# Sydney Metropolitan Development Authority

28 June 2011

**RE: MAJOR PROJECT – EXHIBITION OF ENVIRONMENTAL ASSESSMENT FOR SYDNEY UNIVERSITY ABERCROMBIE PRECINCT REDEVELOPMENT (MP07\_0158)**

SITE PLAN

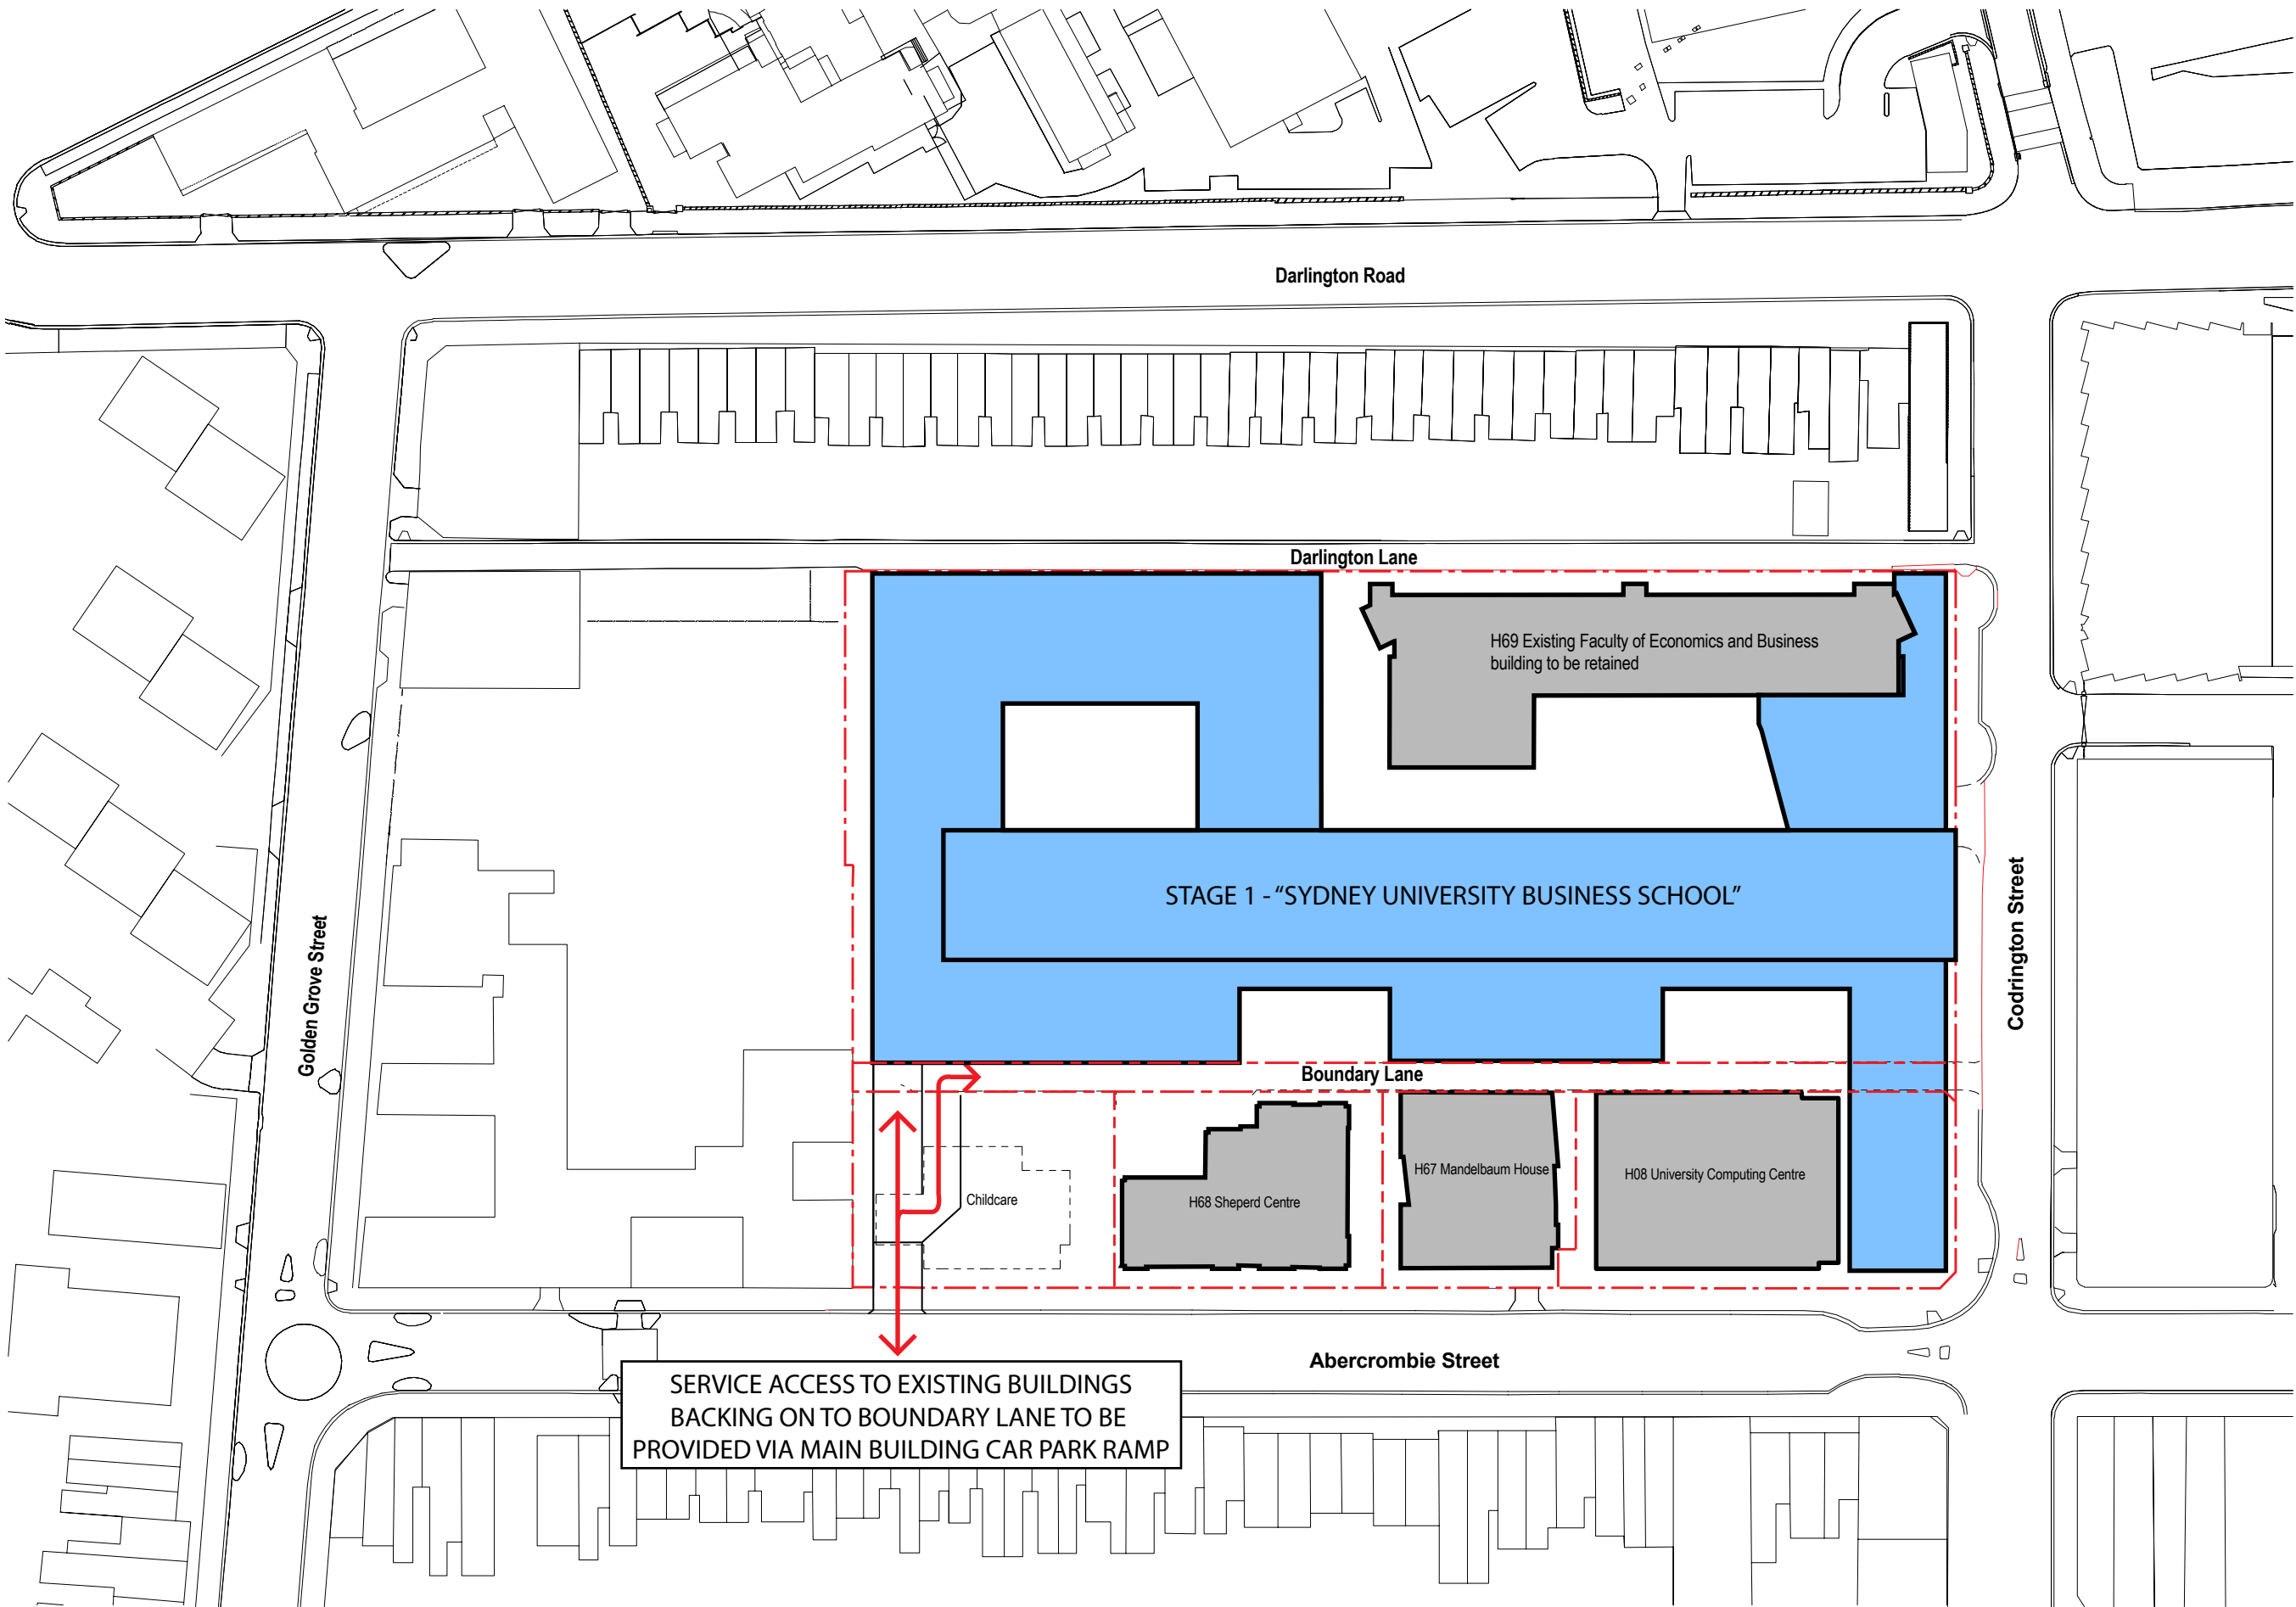
The site is characterised by a change in floor levels from Darlington Lane (RL 29.75) falling to (RL 26.00) at the southern student courtyard. A series of steps is proposed from Darlington Lane down to the central half of the development. It is considered that accessibility would be improved by the provision of lift access near the Darlington Lane pedestrian through site link, to facilitate greater access for persons with limited mobility across the site.

STAGE 2 PLAN

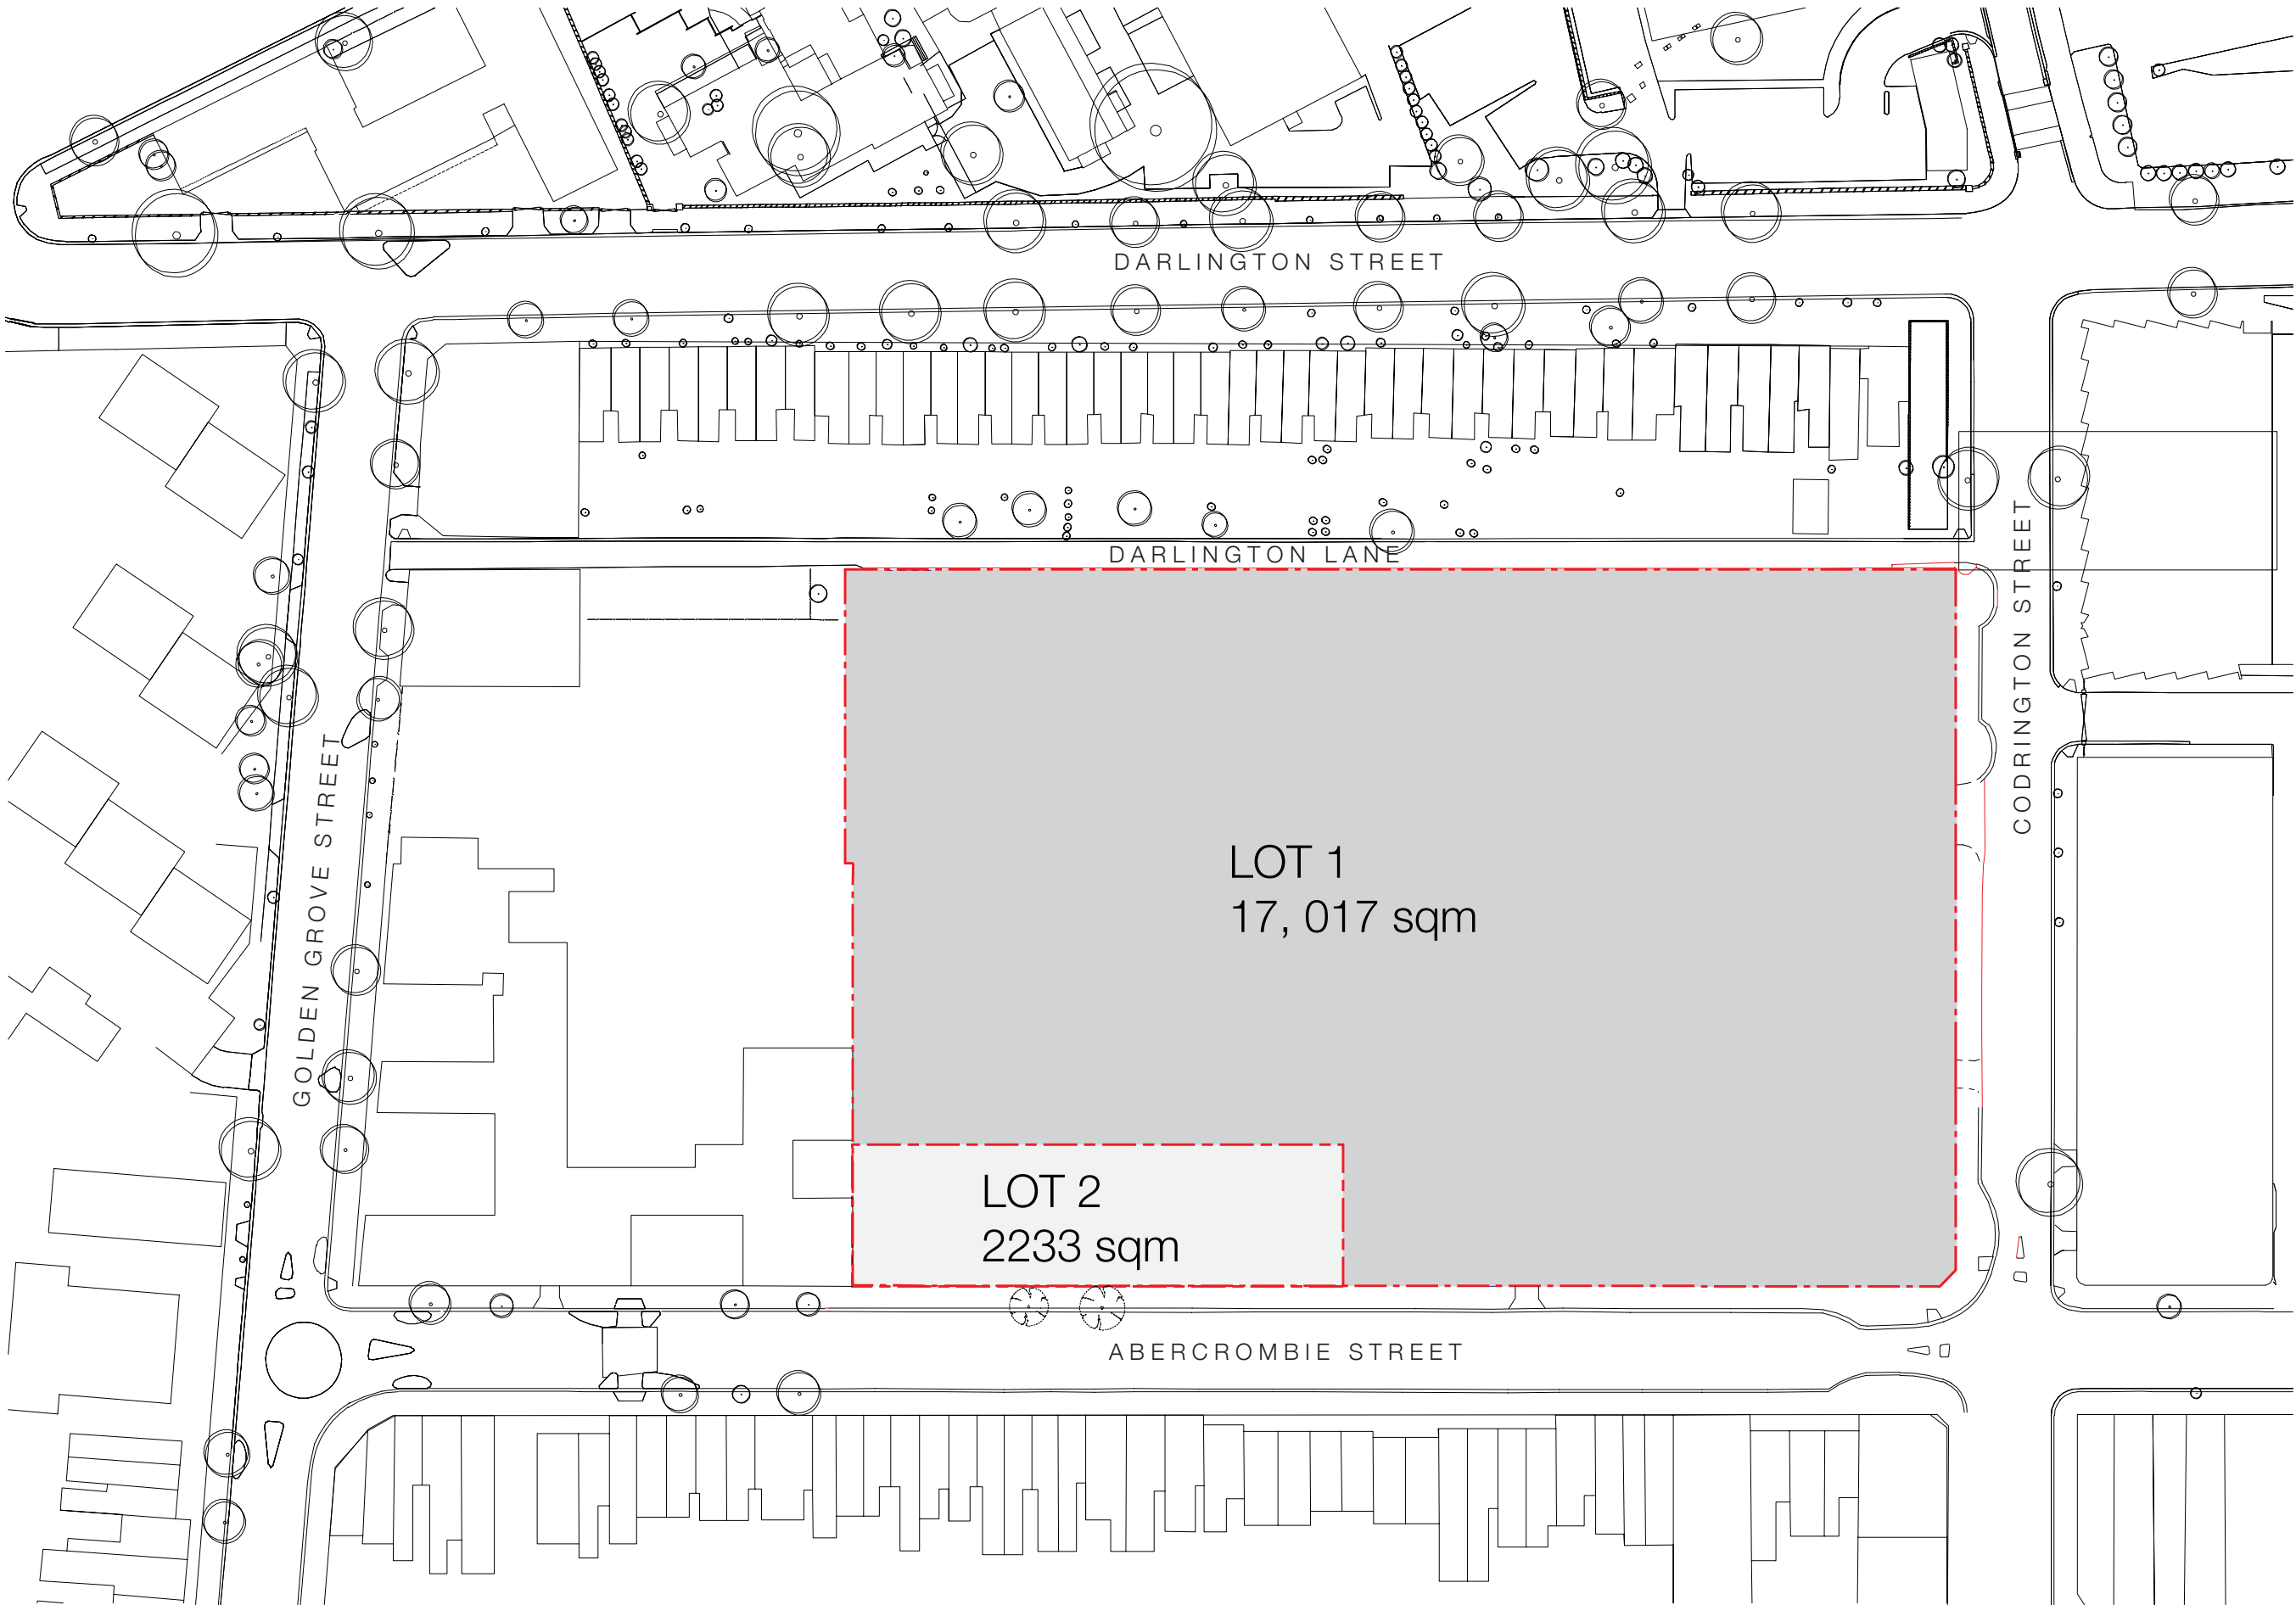
Part of the Stage 2 development involves the removal of a Child Care Centre and a Shepherd Centre Building, both providing a valuable community facility, and the Shepherd Centre being a regionally significant facility for people with hearing impairments. The demolition of these buildings should be subject to their appropriate relocation elsewhere on the University Campus, to ensure continuity of service. This is discussed further later in this submission.

The EA indicates that the Boundary Lane Childcare Centre, which is located on the site, will be demolished to accommodate the new development. Page 13 of the EA includes a footnote which states that the childcare centre would be "relocated to another site (provisionally identified as a University site on Burren Street) subject to a separate application". Aside from this statement the SMDA has been unable to find further details regarding the relocation of the childcare centre within the documentation.

The EA also identifies the Shepherd Centre building will also be demolished. This building currently accommodates a facility for deaf and hearing-impaired children, and is a regionally significant facility. The SMDA assumes this facility will be relocated elsewhere as part of stage 2 of the development and seeks confirmation of this. To this effect the SMDA requests that the replacement of the Shepherd Centre be specifically addressed in the State of Commitments, and included as a condition on any approval issued. The conditions/commitments should ensure continuity of service.
